Final Acceptance (FA) Punchlist
EPC - DPW - Stormwater Section

Project Name:	Creekside at Lorson F1
EDARP Filing Number(s):	CON1910
ESQCP Number:	ESQ 1911
Attendees:	DPW SW: Natasha Grimaldo, Ben Jones DPW Planning: N/A Developer: Jeff Mark/Lorson LLC
Date of Walk-Thru:	2/14/2023
Walk-Thru Number:	1 st

DATE: SEPT 19, 2019
 PROJECT NO. 100.045
 SHEET NUMBER **C9.7**
 TOTAL SHEETS: 34

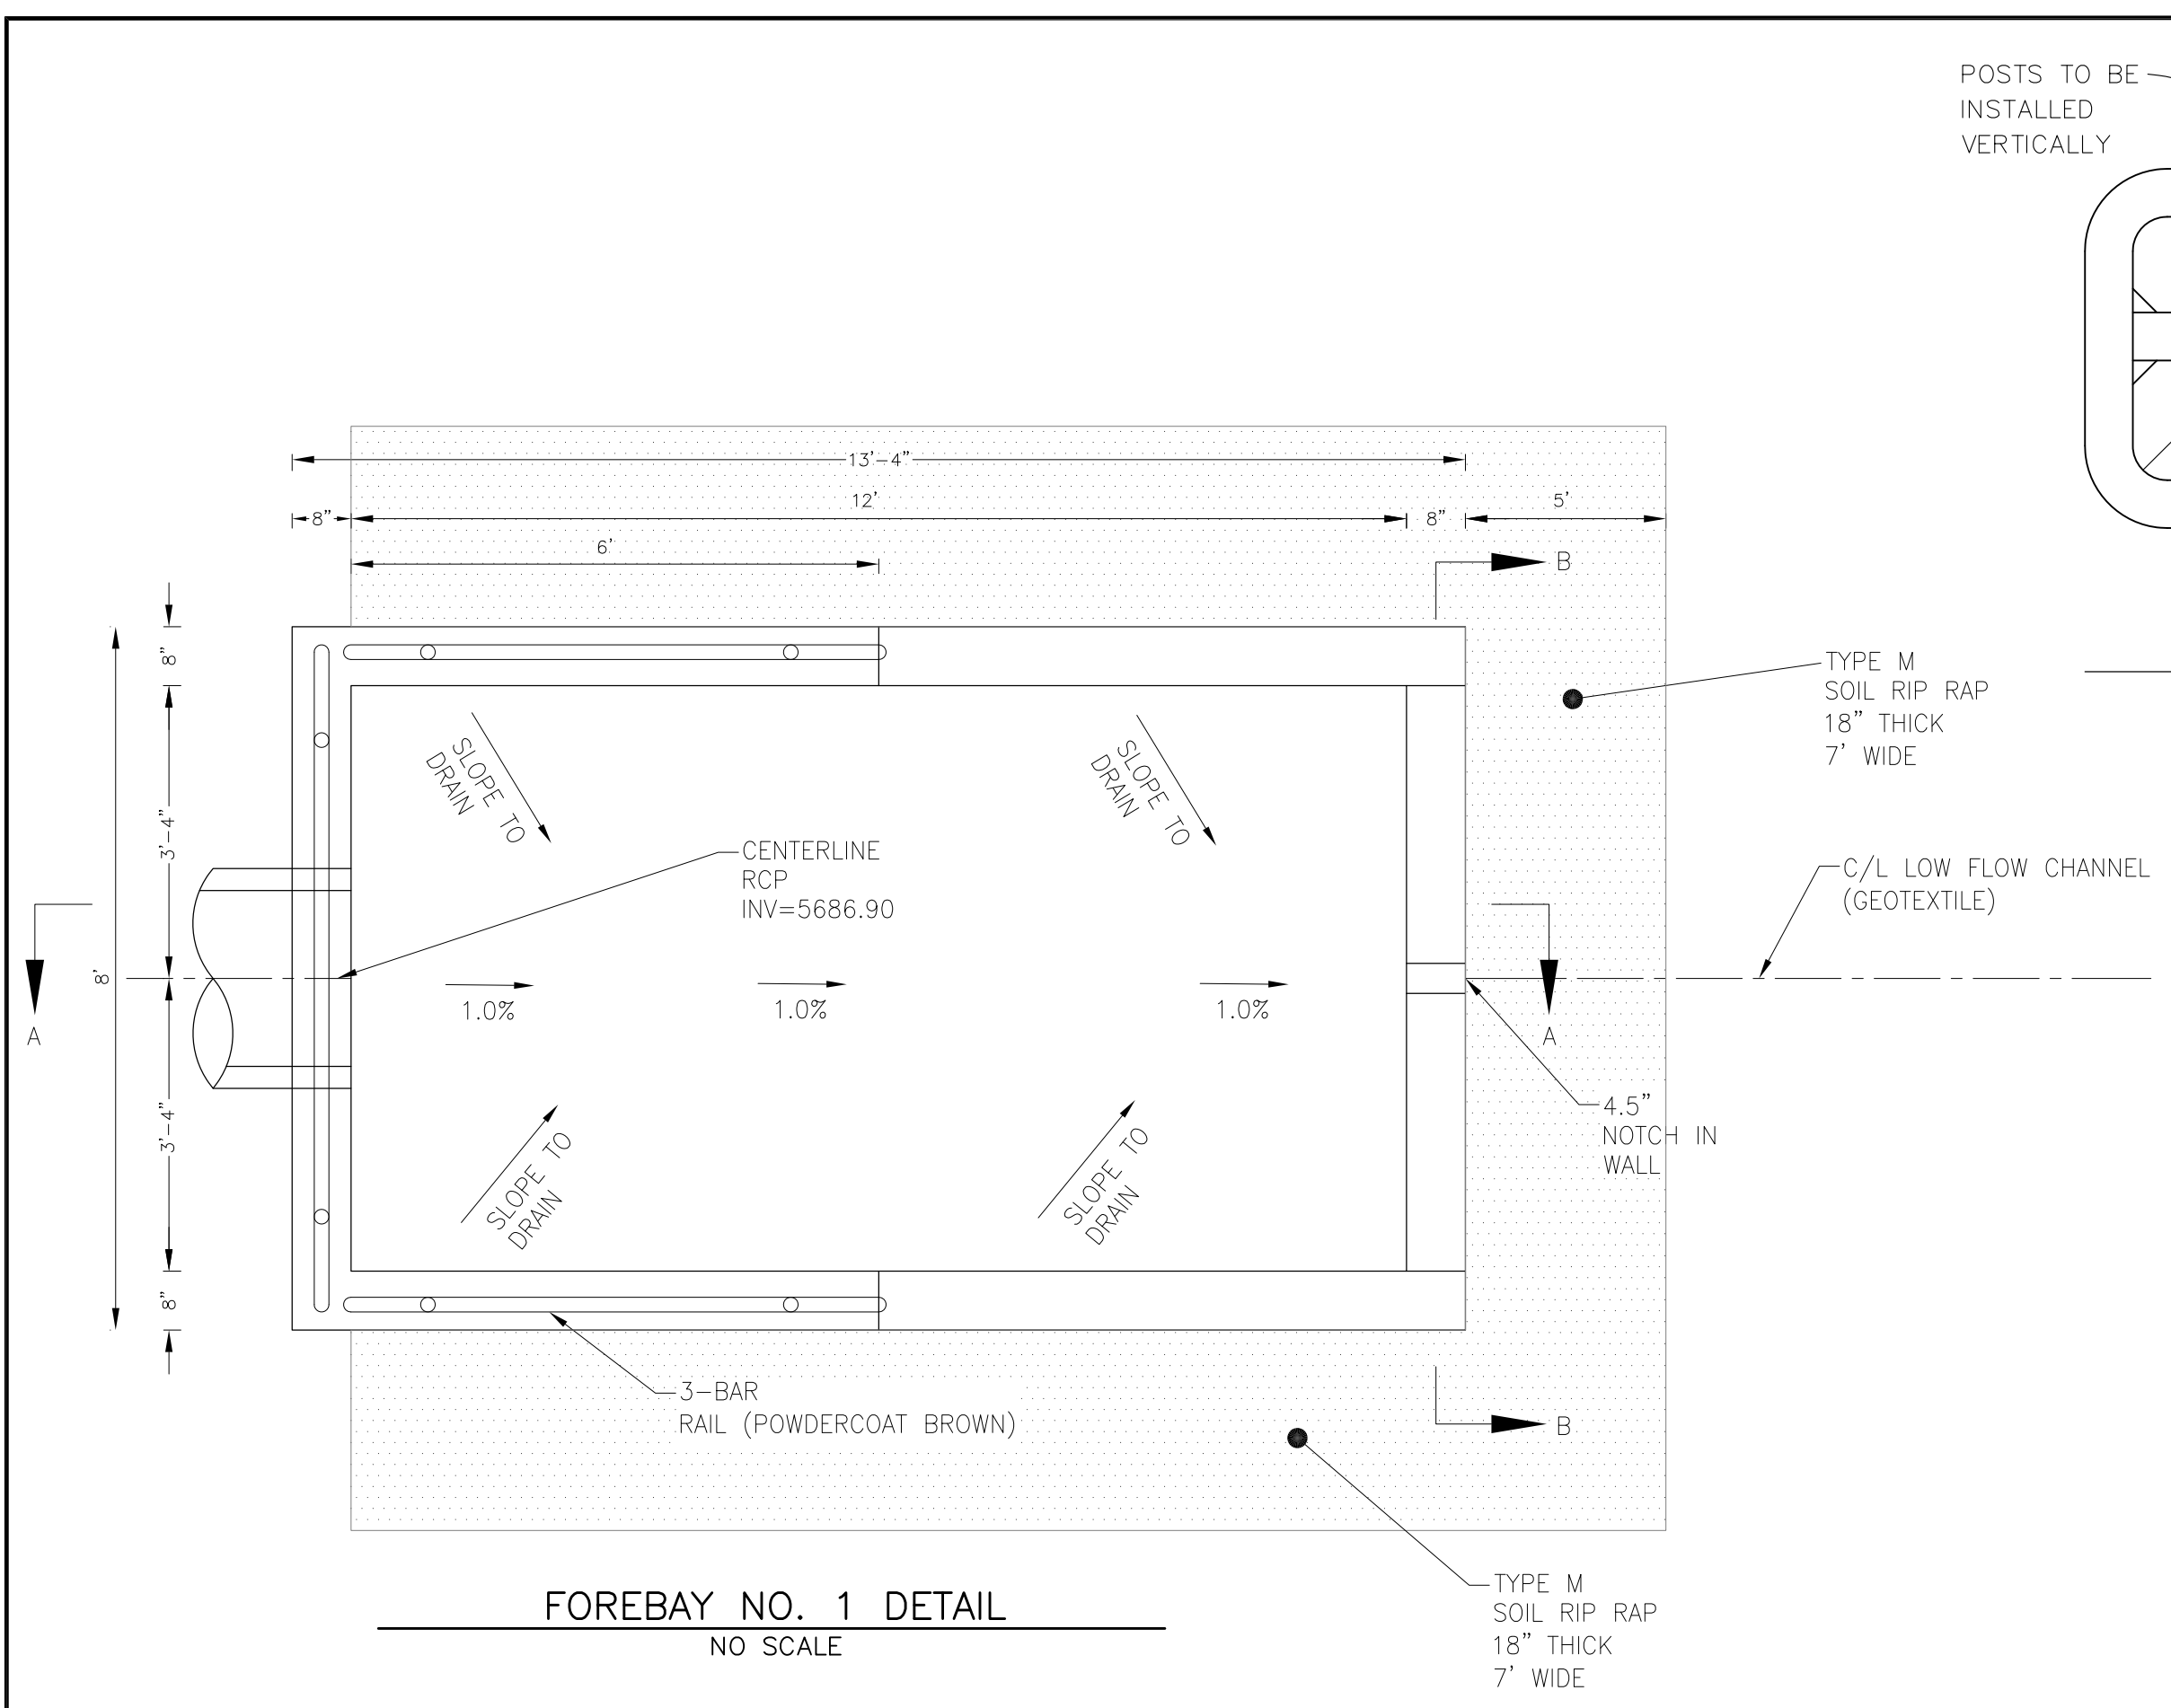
- Remove vegetation from the base of the sand filter basin.
- Failure to implement Steel Restrictor Plate at underdrain outlet. Reference page C9.4 Creekside at Lorson Ranch filing No. 1 Street and Storm Sewer Construction Plans.
- Remove straw wattle from along the access road.

Photo 13: Pond CR3: Failure to implement Steel Restrictor Plate. Reference page C9.4 Creekside at Lorson Ranch filing No. 1 Street and Storm Sewer Construction Plans.

FOREBAY NO. 1, 2 A, & 2B
DETAILS

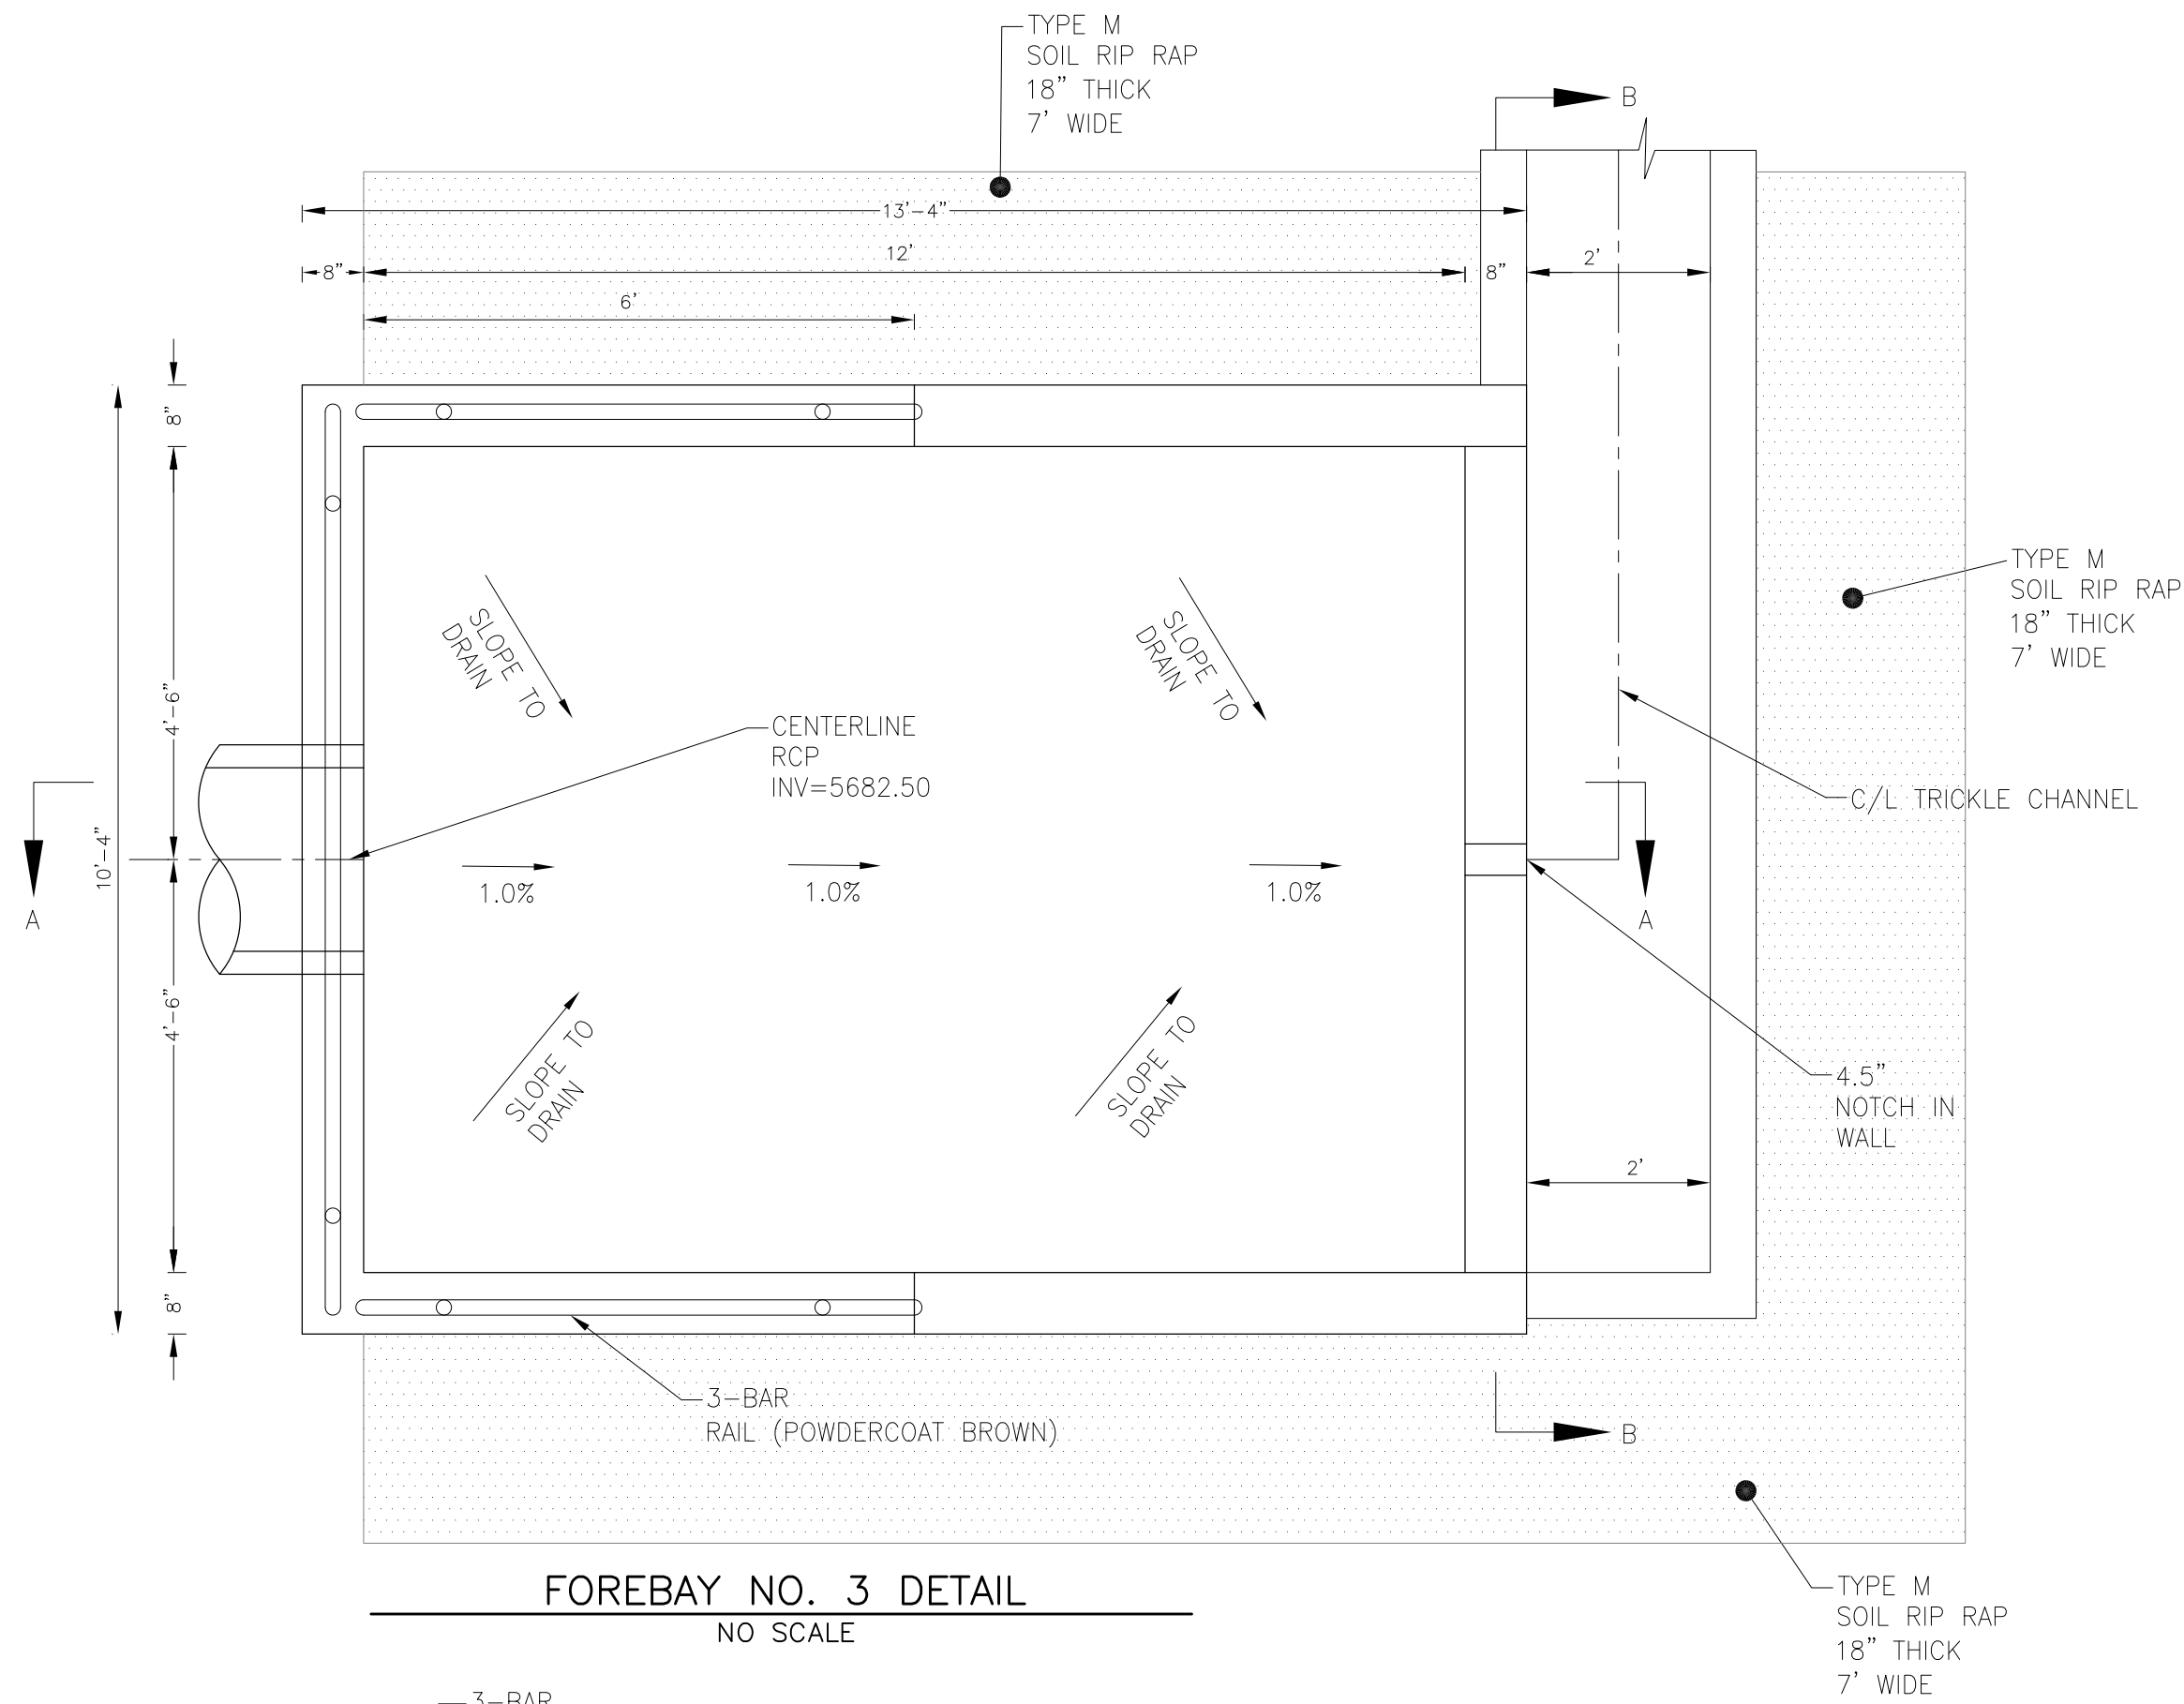
- Implement missing bolts on outlet structure top grates (approximately 11 missing).
- Forebay No. 2B: Failure to implement soil rip rap per approved plans. Page C9.8 Creekside at Lorson Ranch filing No. 1 Street and Storm Sewer Construction Plans.
- Forebay No. 2B: Repair crack in trickle channel.
- Forebay No. 2A: Repair crack in trickle channel.
- Forebay No. 2A: Clean sediment and debris out of forebay and pipe.
- Forebay No. 1: Clean sediment and debris out of forebay and pipe.
- Behind Forebay No. 1: Remove old roll of Erosion Control Blanket.
- Outfall - Note that this is not an FA item, but a maintenance item, just listed here as an FYI: Advise cleaning out the outfall area and grade to create positive drainage.

Photo 2: forebay No. 2B: Failure to implement soil rip rap per approved plans. Page C9.8 Creekside at Lorson Ranch filing No. 1 Street and Storm Sewer Construction Plans.
